Engineers Comments Regarding Surface Water Drainage

Application Reference:	BR/198/25/PL	Reviewer Reference:	ADC/EXT5/AF
Planning Officer:	Hebe Smith	Date of Review:	29/12/2025
Site Name:	The Regis School Campus Westloats Lane Bognor Regis PO21 5LH		
Application Description:	Installation of a four-lane outdoor caged cricket net facility. This application is in CIL Zone 4 (Zero Rated) as other development.		
Assessment Number:	1

Block Plan for The Regis School, Westloats Lane, Bognor Regis, PO21 5LH (with dimensions)

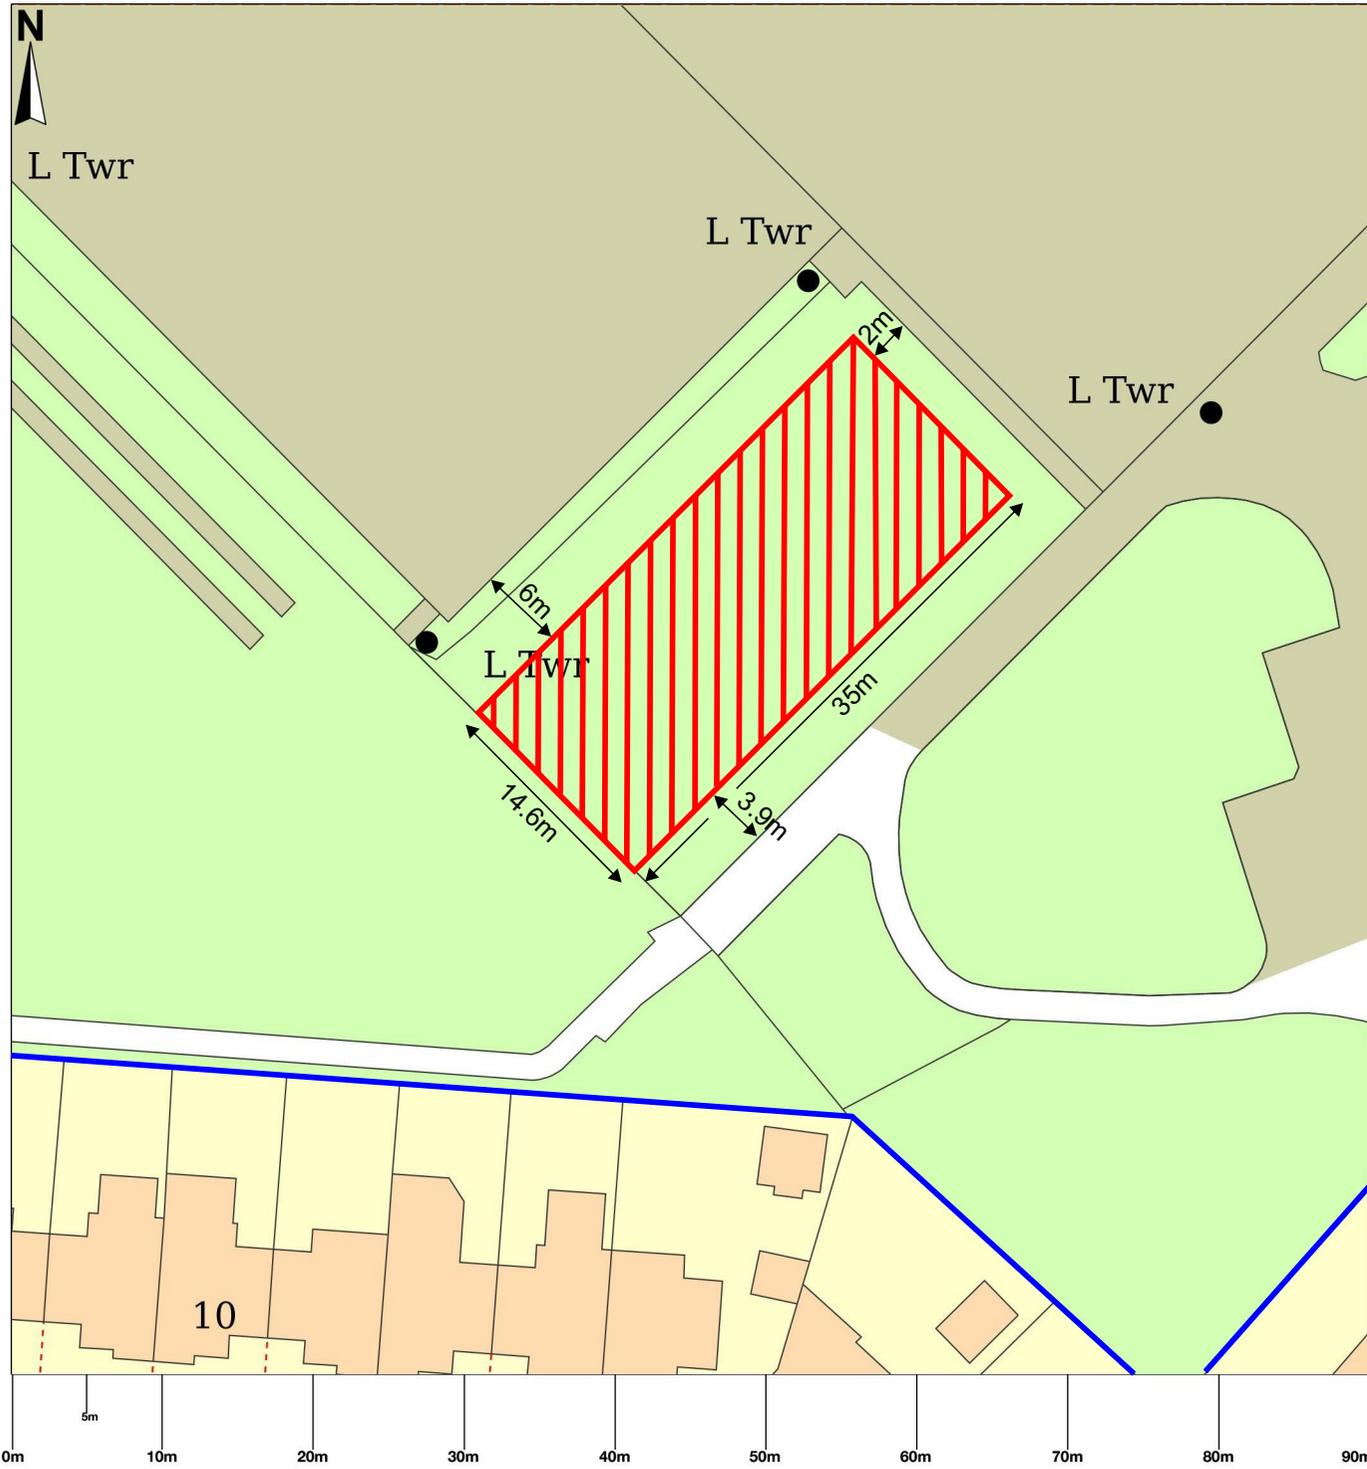
- 3.1. Calculations have not been provided to demonstrate the effectiveness of the proposed drainage system for large return period storms. The development may therefore increase runoff from the development.
- 3.2. There is an area of High and Medium surface water flood risk within the area of works which may affect the ability of the drainage system to effectively drain the paved area. This is not currently addressed in the submission.
- 3.3. Management of extreme rainfall is not currently in accordance with the requirements of the NSfS. Therefore, we **object** to the application.
